Consultation Response from KC Landscape	
Application No:	2025/92776
Proposed Development:	Outline application, with all matters reserved, for residential development [110 dwellgs], with associated open space, landscaping, drainage infrastructure and associated works
Location:	land at, Eastfield, Shepley, Huddersfield, HD8 8HB
Applicant/Agent:	Banks Group Ltd
Planning Officer	Louise Bearcroft
Date Responded:	08.01.2026
Responding Officer:	Landscape
Responding Ref:	PP56

NOTES/COMMENTS: These comments are Without Prejudice

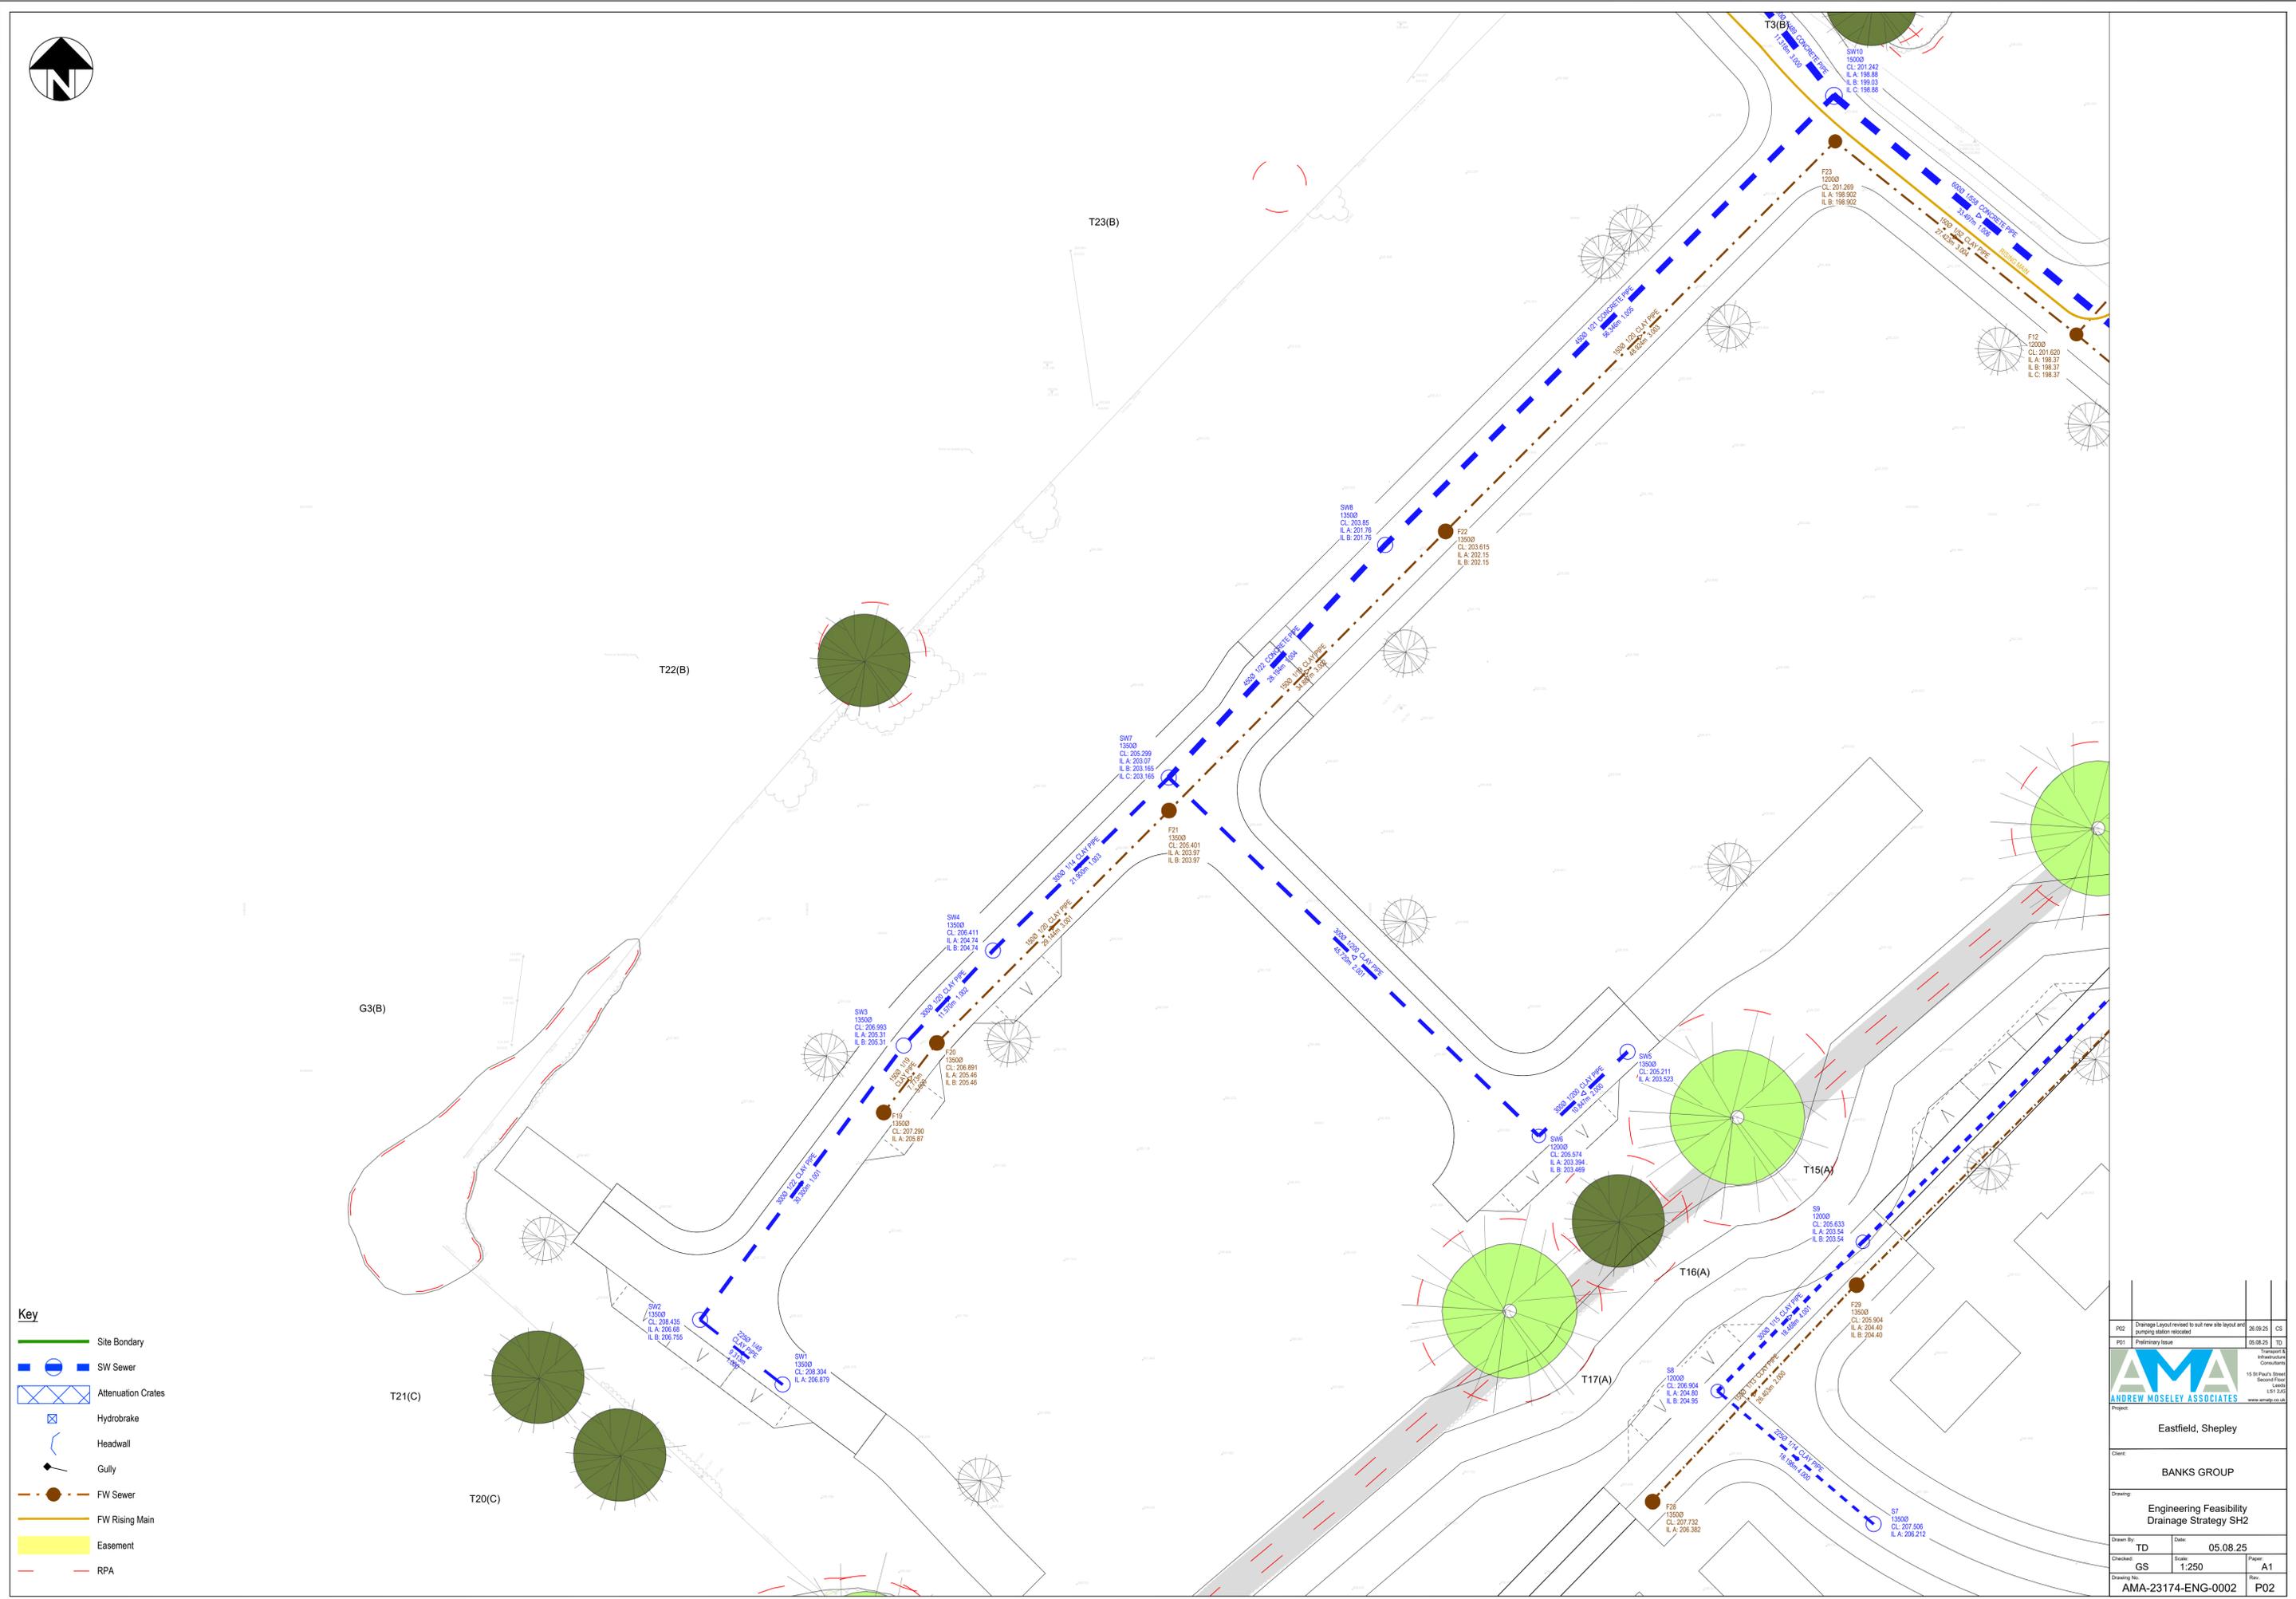
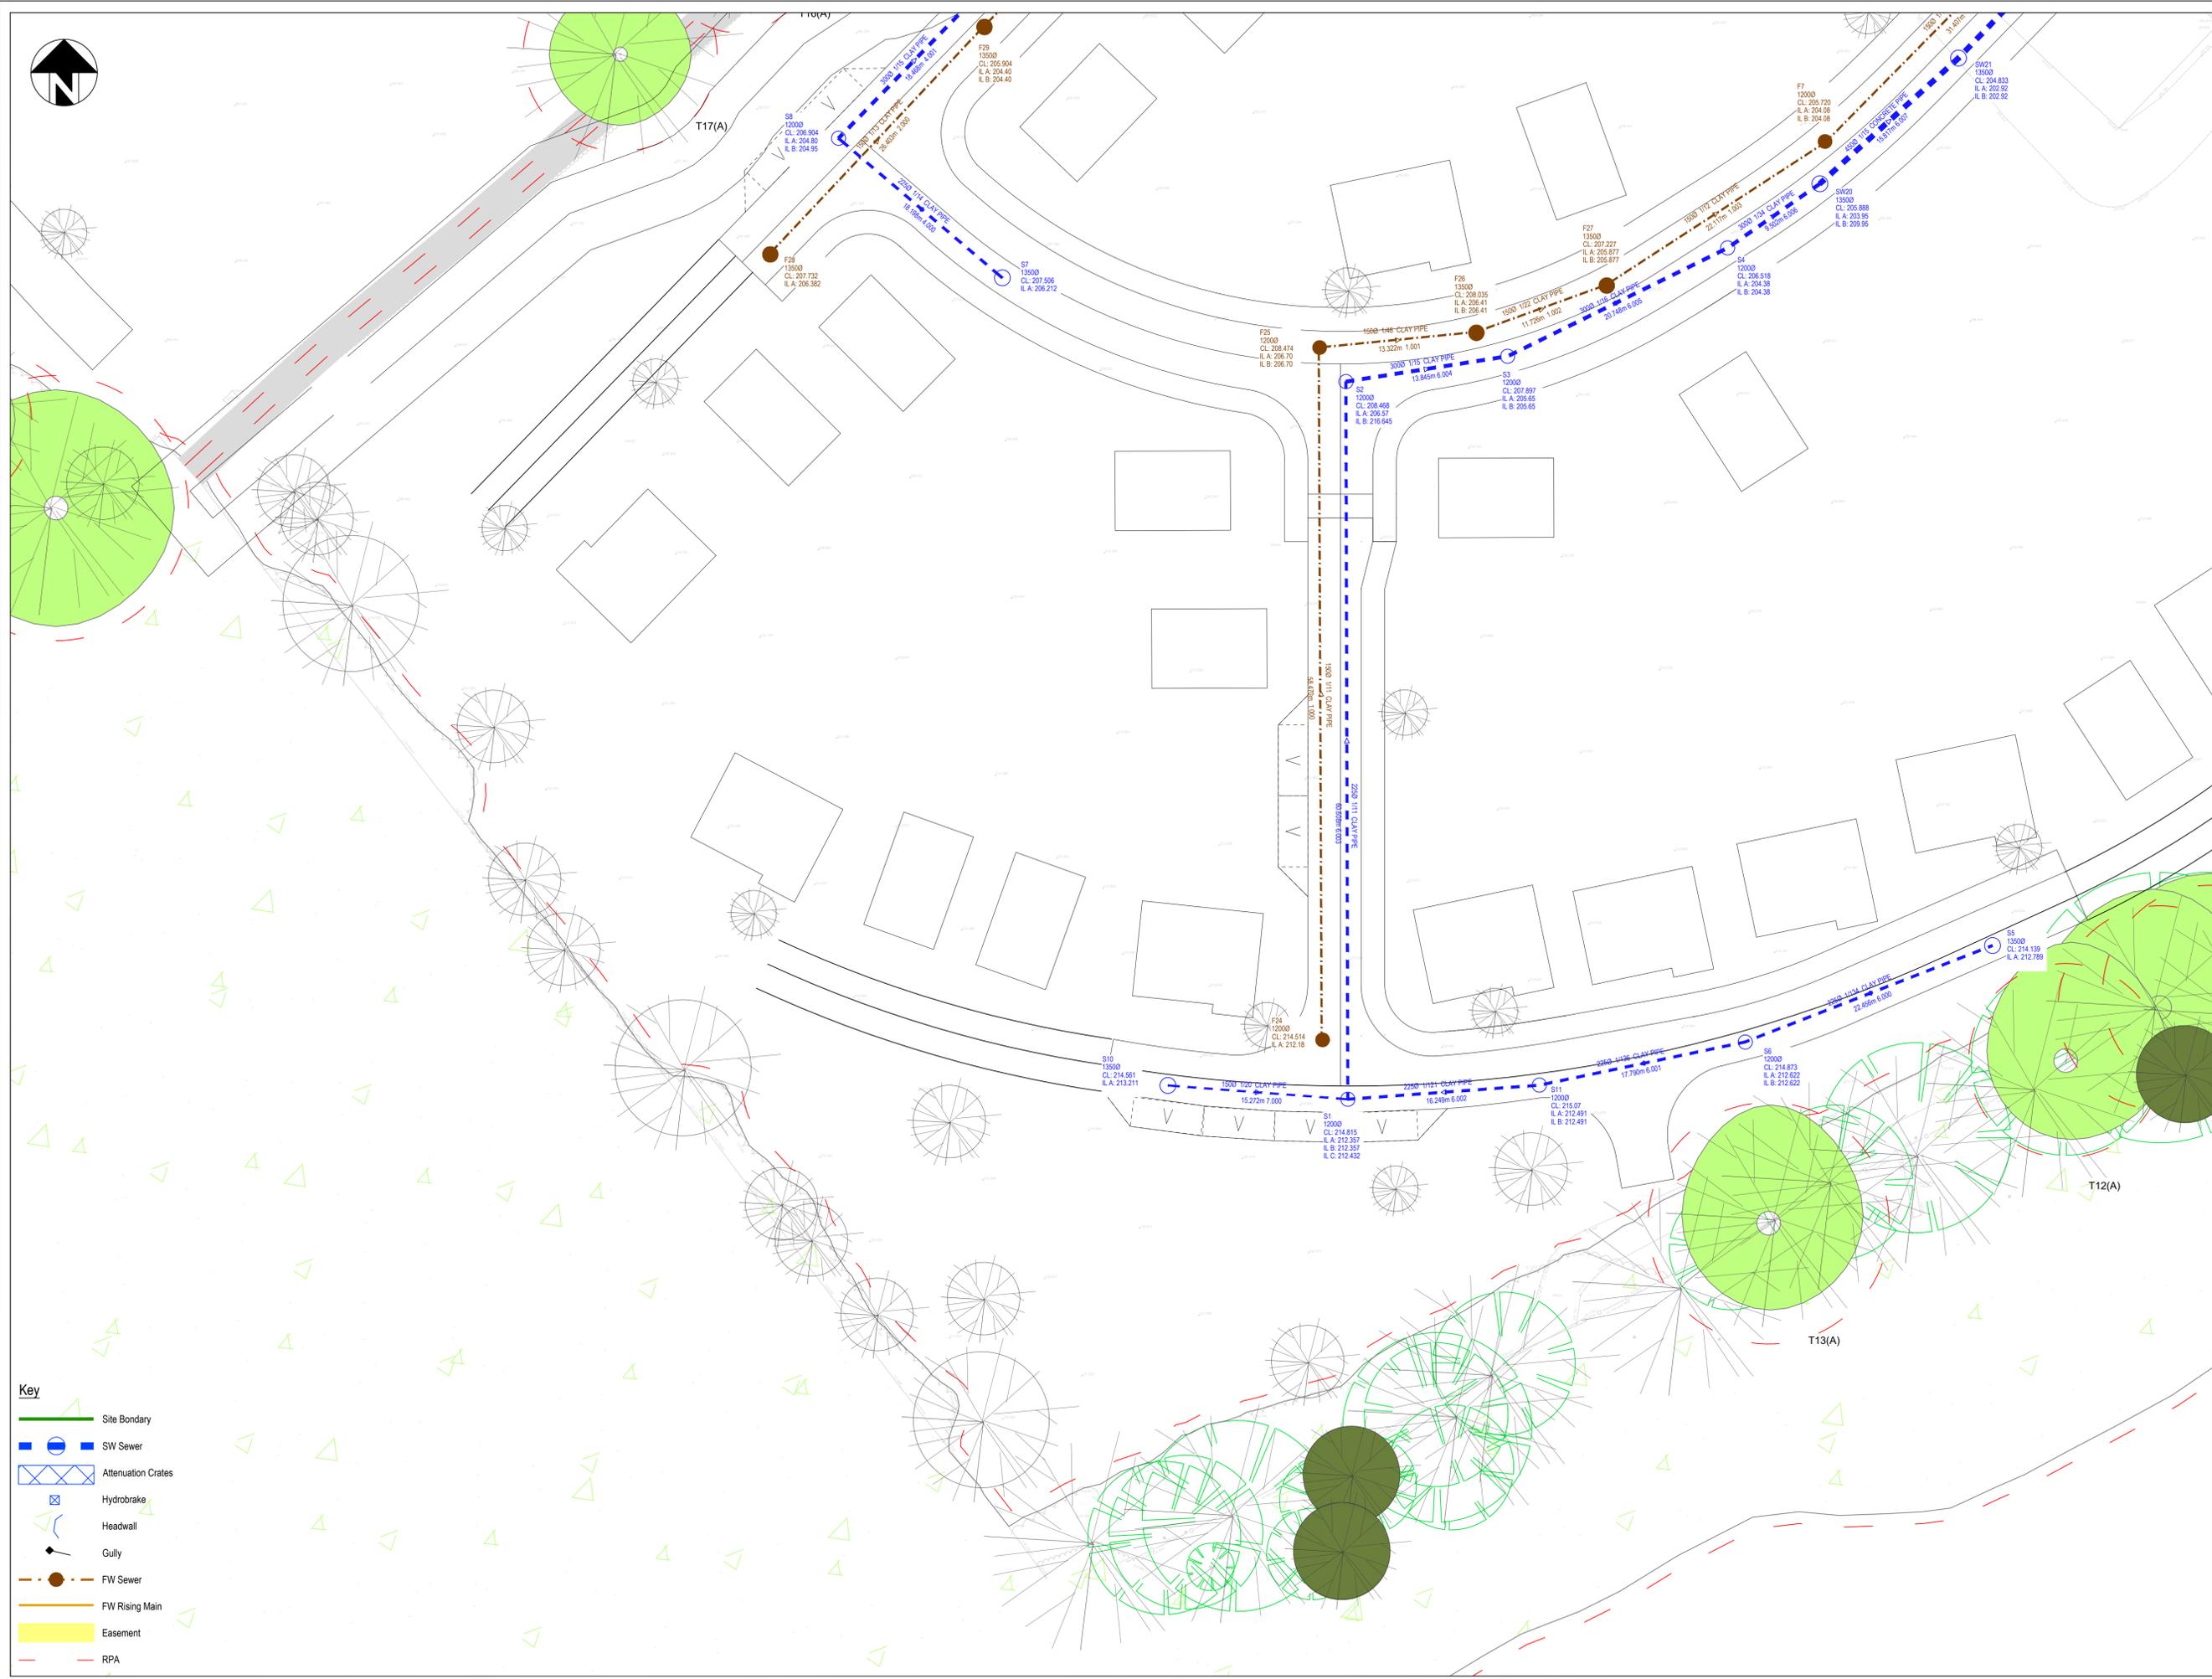
5. We have concerns that the attenuation feature will impact the proposed landscaping and tree planting to one of the areas proposed as a public open space.

6. Plans should clearly show the impact of the proposed landscape planting on drainage infrastructure and visibility spays, particularly with proposed street trees and frontline tree planting/ trees in front gardens.

37. SuDS: Enhancing and including Nature-Based Solutions: how does this scheme integrate nature-based solutions, particularly to enhance the ecological function of the landscape. Consideration of retention ponds, rain gardens, and bio-swales in softscape areas to mitigate flooding, slow the flow and improve water quality and how does this meet the needs of accessible and attractive useable POS in this location? Can this site include trees in the locations proposed on top of the attenuation infrastructure?

1. Measured areas should relate to typologies of open space (LP63) and we have concerns that there may be a conflict with attenuation features and tree and shrub planting and public open space infrastructure;

- Please show drainage infrastructure on the landscaping plans, to demonstrate no conflict between landscape proposals, shrubs, trees and drainage.
- Please show visibility splays on landscape plans to demonstrate no conflict between landscape proposals, shrubs, trees and vehicular and highways visibility.
- pre-commencement condition is necessary to ensure all details relevant to landscape matters and s106 triggers and requirements for POS and contributions
